Thank you for submitting Planning Application Comments

**Planning Application Reference Number:** 3/2023/0929

**Address of Development:** 1 Talbot Street, Chipping, PR3 2QE

Drawing Number:
440.02-002

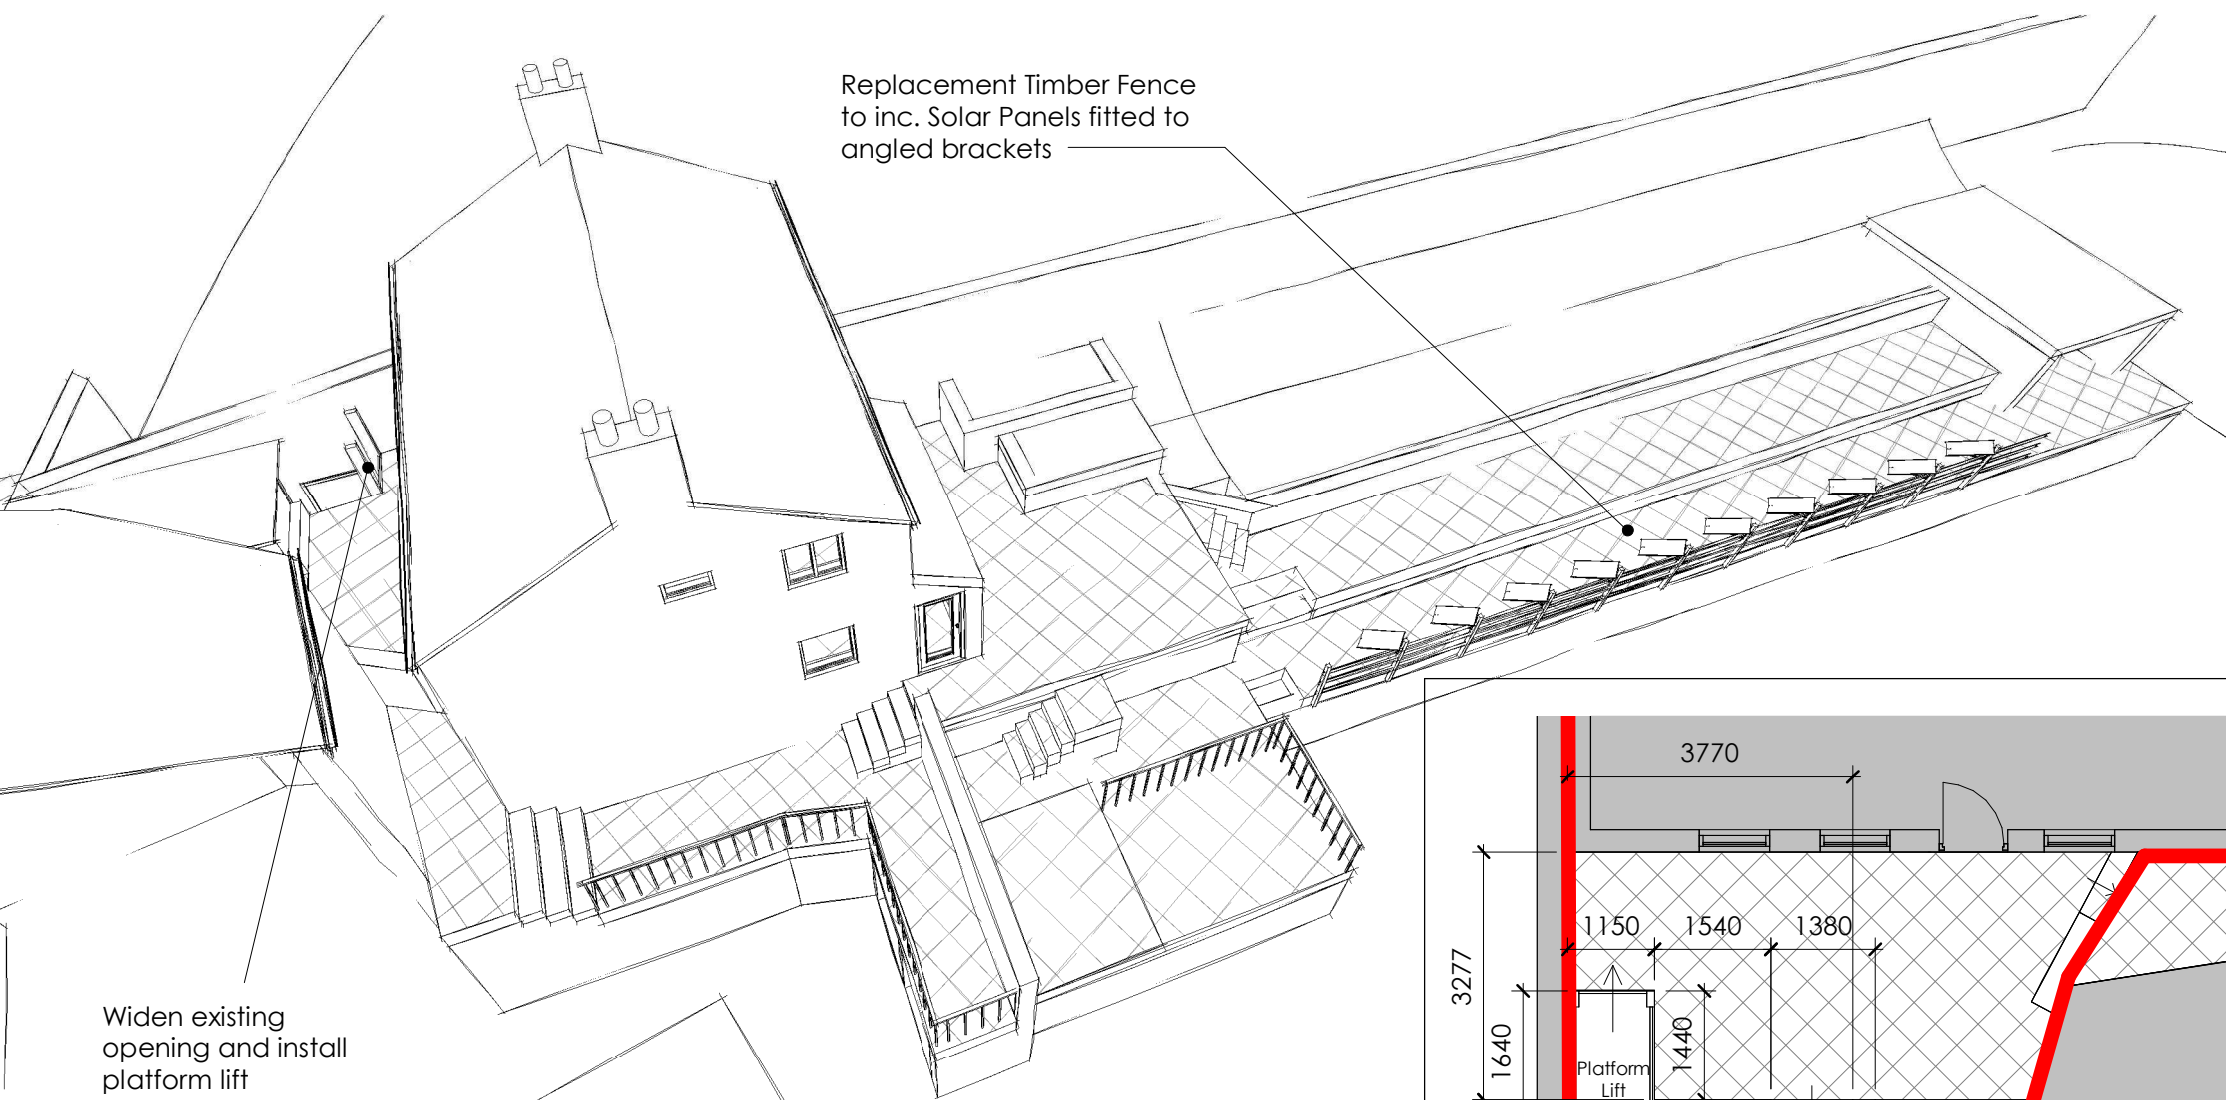
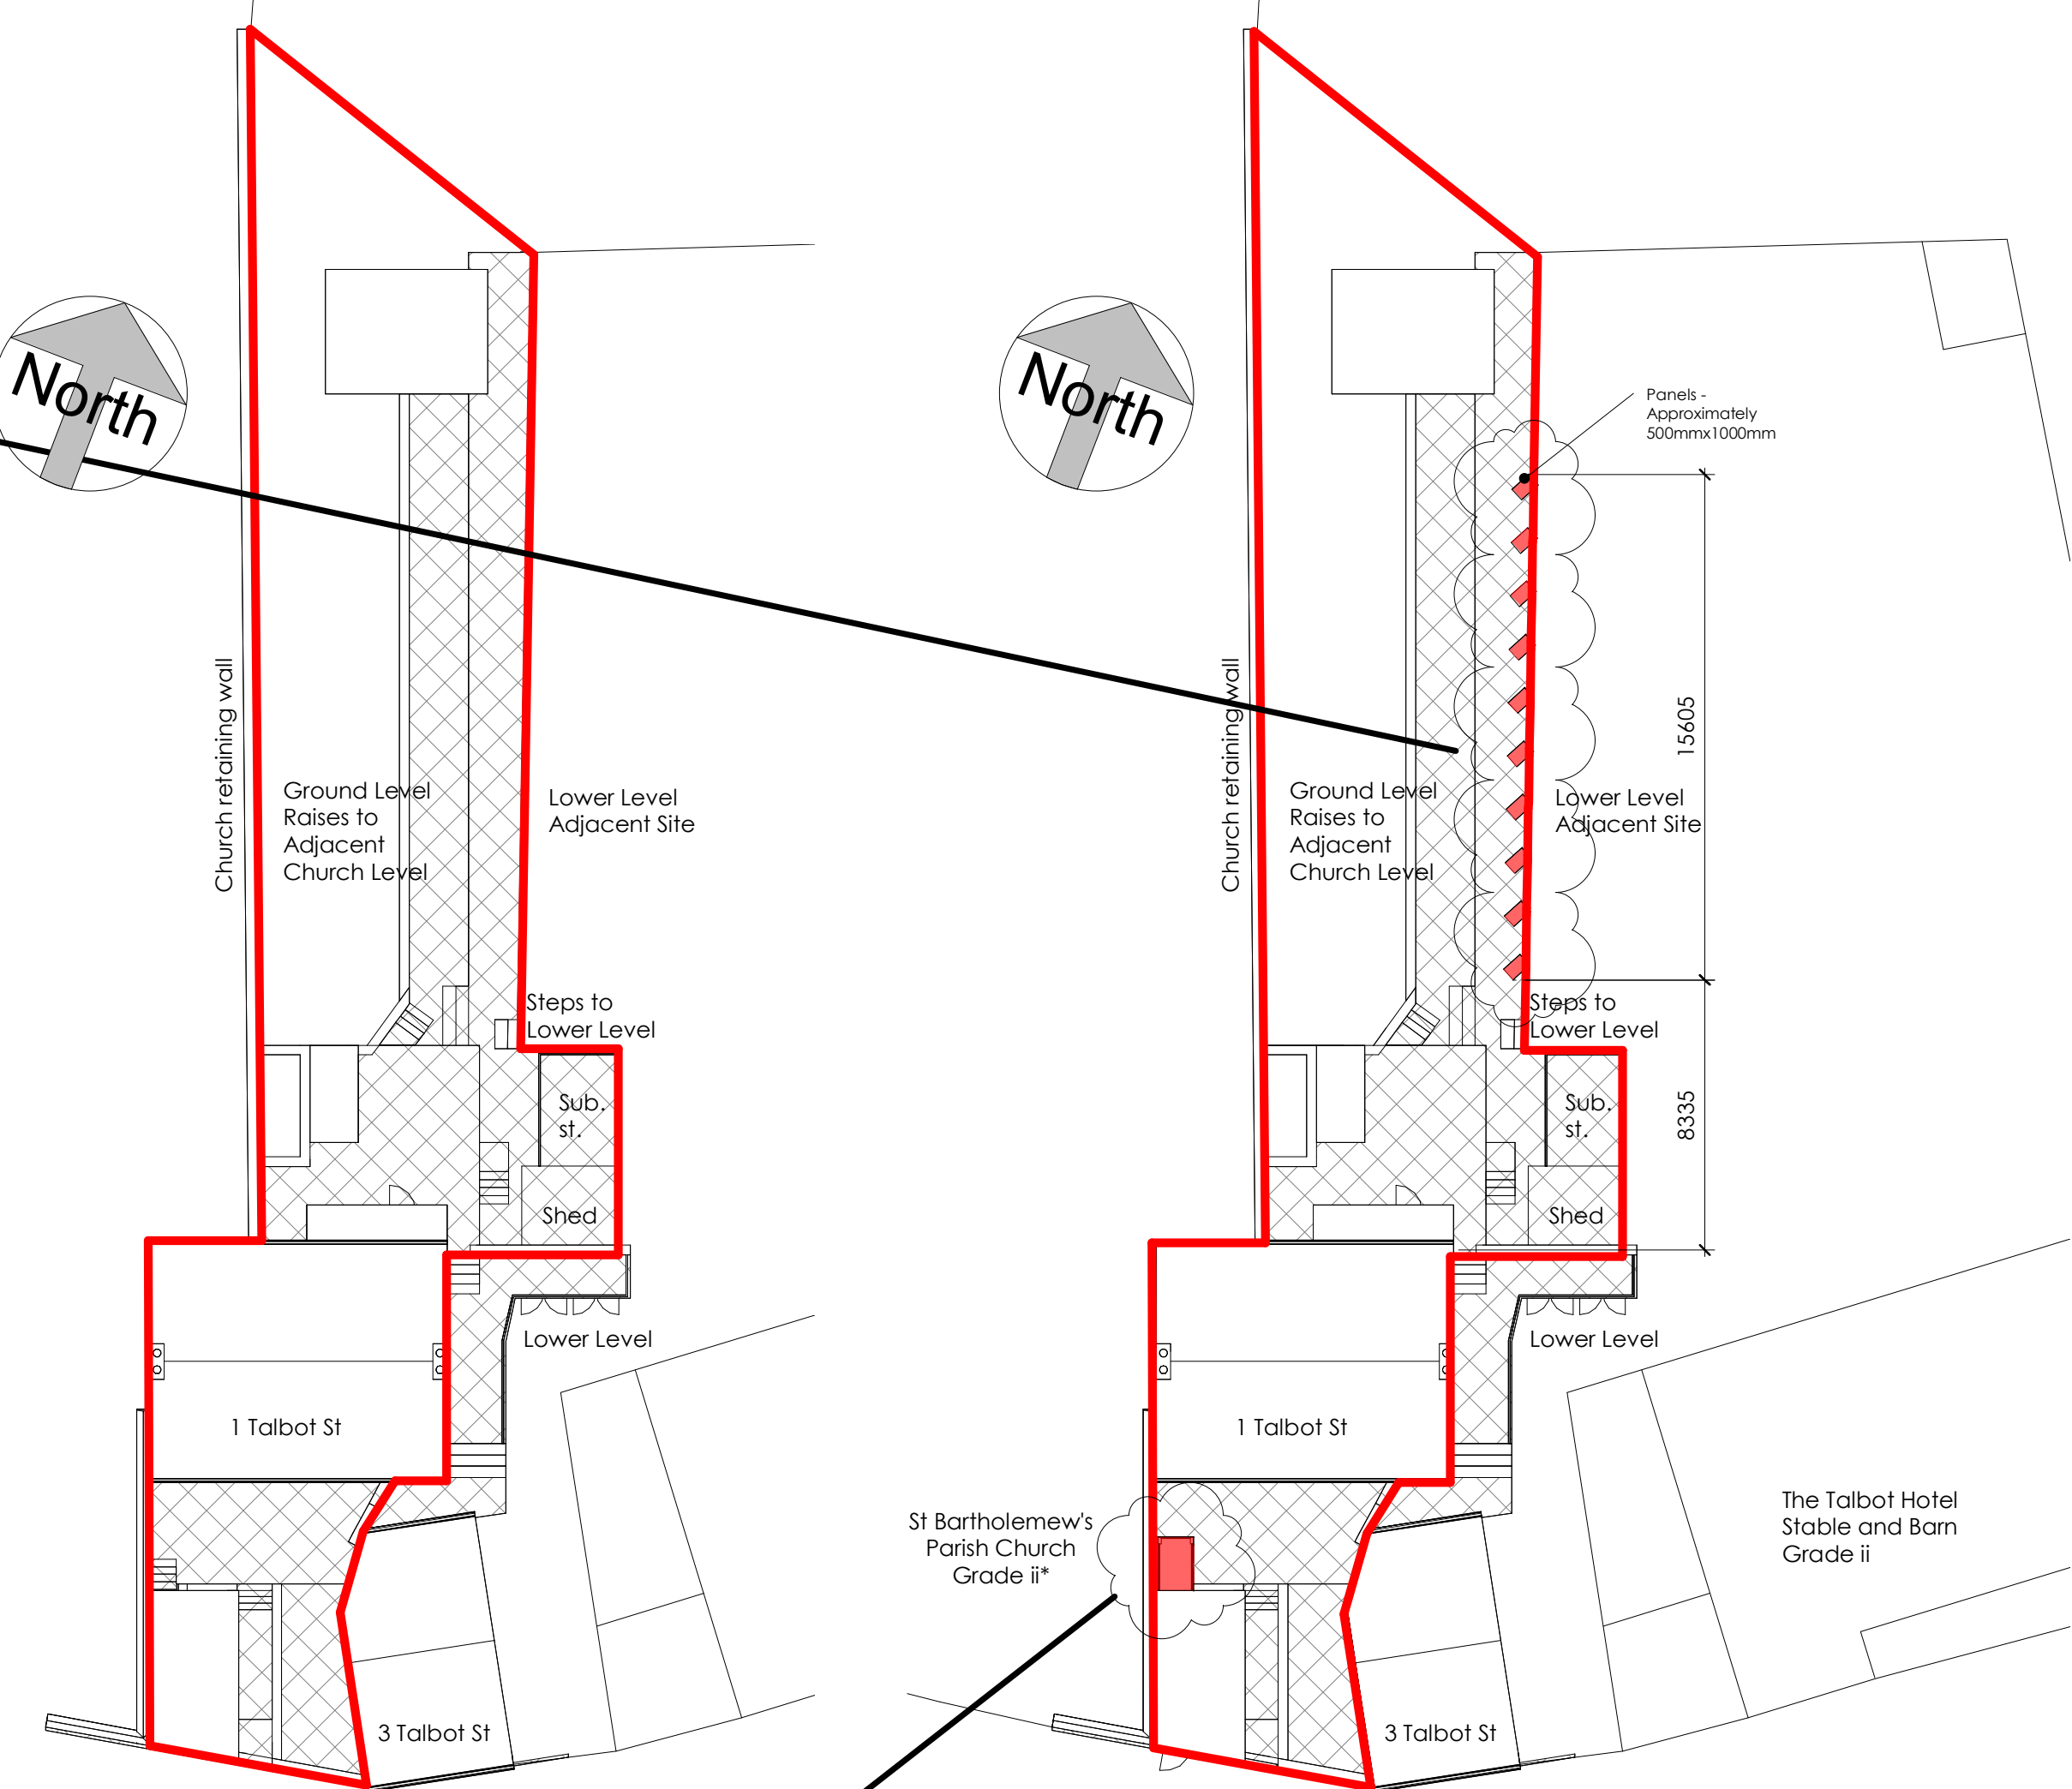
**Your Comments:** The boundary line at the rear of the property where the individual is proposing a fence and solar panels is incorrect within the drawings. The individual is claiming to own land that doesn't belong to him.

Please see title deed at the land registry [REDACTED]. Firstly you will note that from the title deeds, where his shed is currently located, this actually belongs to No 3 Talbot street. This is identifiable by the boundary line on [REDACTED] at the edge of the electric sub station, there is a grey line that goes to the corner of the rear of No 1 Talbot Road and then from there to the raised wall on the left of the sub station belongs to No 3 and not No 1. Also it should be noted that the sub station is again on the land owned by the [REDACTED] [REDACTED] This does not belong to the applicant.
